15 September 2011
Ref 10063

**PROPOSED MIXED USE DEVELOPMENT
23-37 LINDFIELD AVENUE & 11 HAVILAH AVENUE, LINDFIELD
REVISED VEHICULAR ACCESS & CARPARKING ARRANGEMENTS**

As requested, I have reviewed the vehicular access and carparking arrangements illustrated on the revised plans, copies of which are attached.

DRAWING TITLE:
GROUND FLOOR PLAN

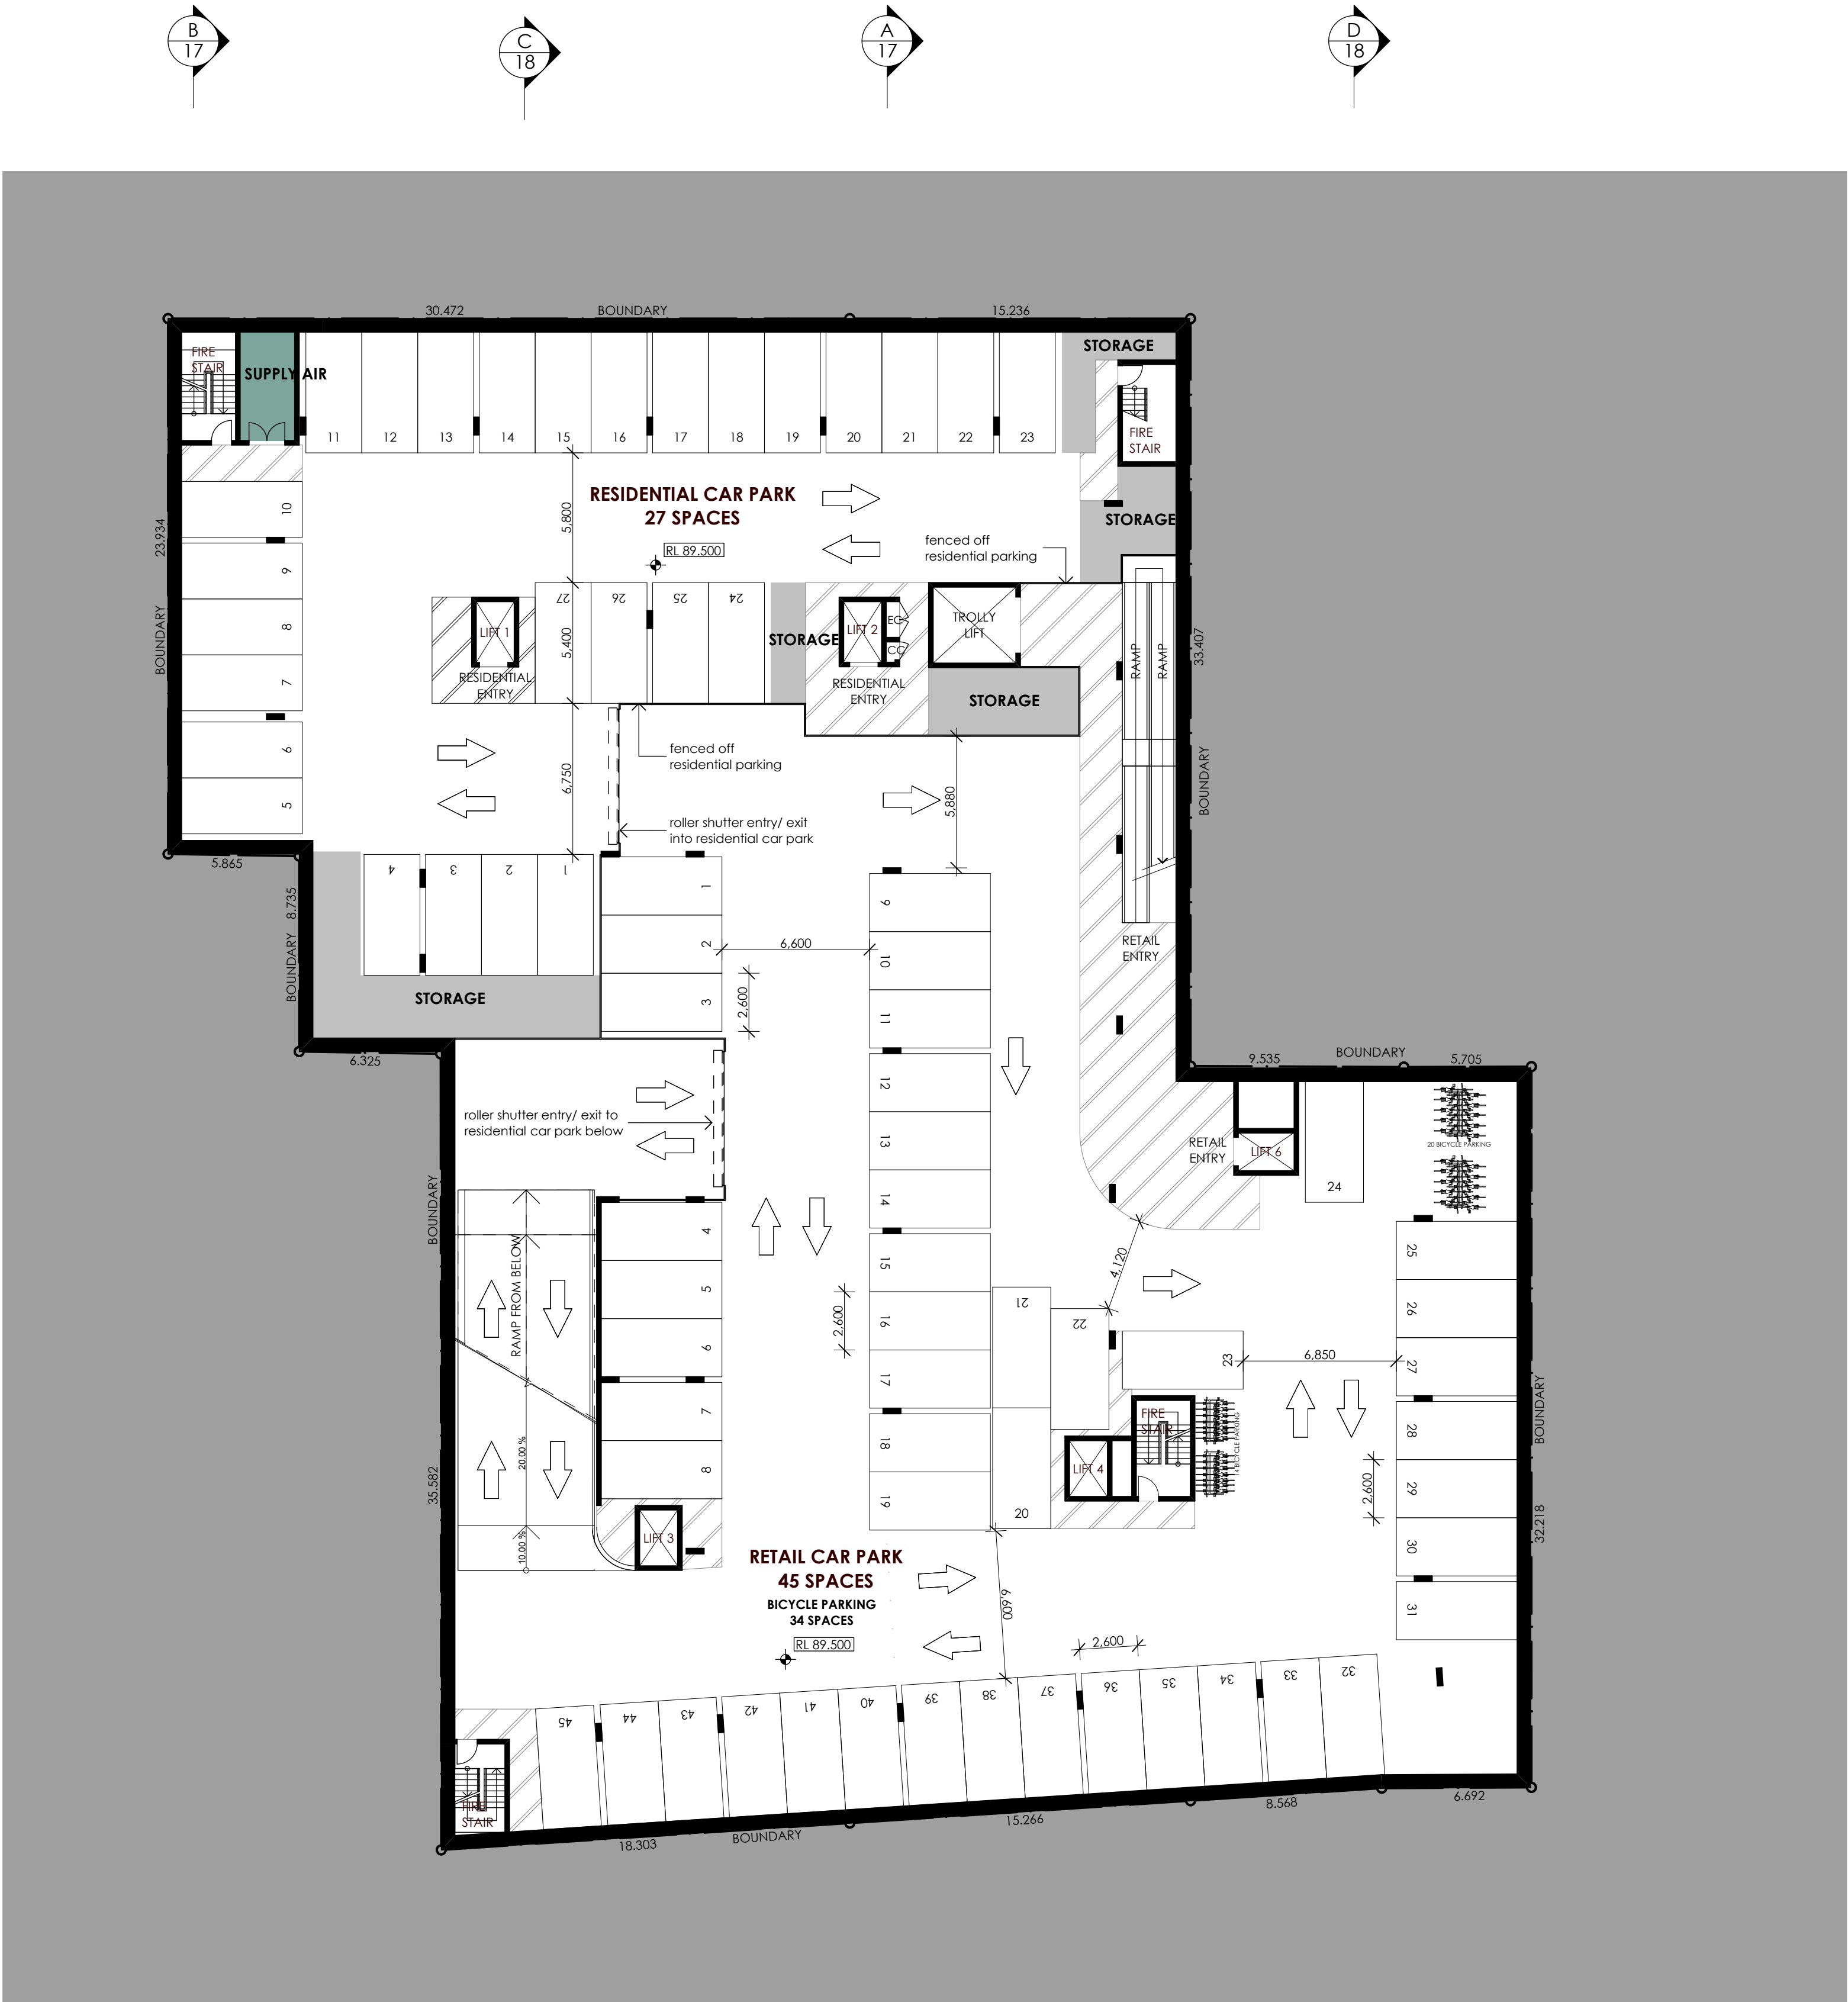
I can confirm that the revised vehicular access arrangements make provision for a driveway in Havilah Lane with a minimum width of 7m, as requested by the Council.
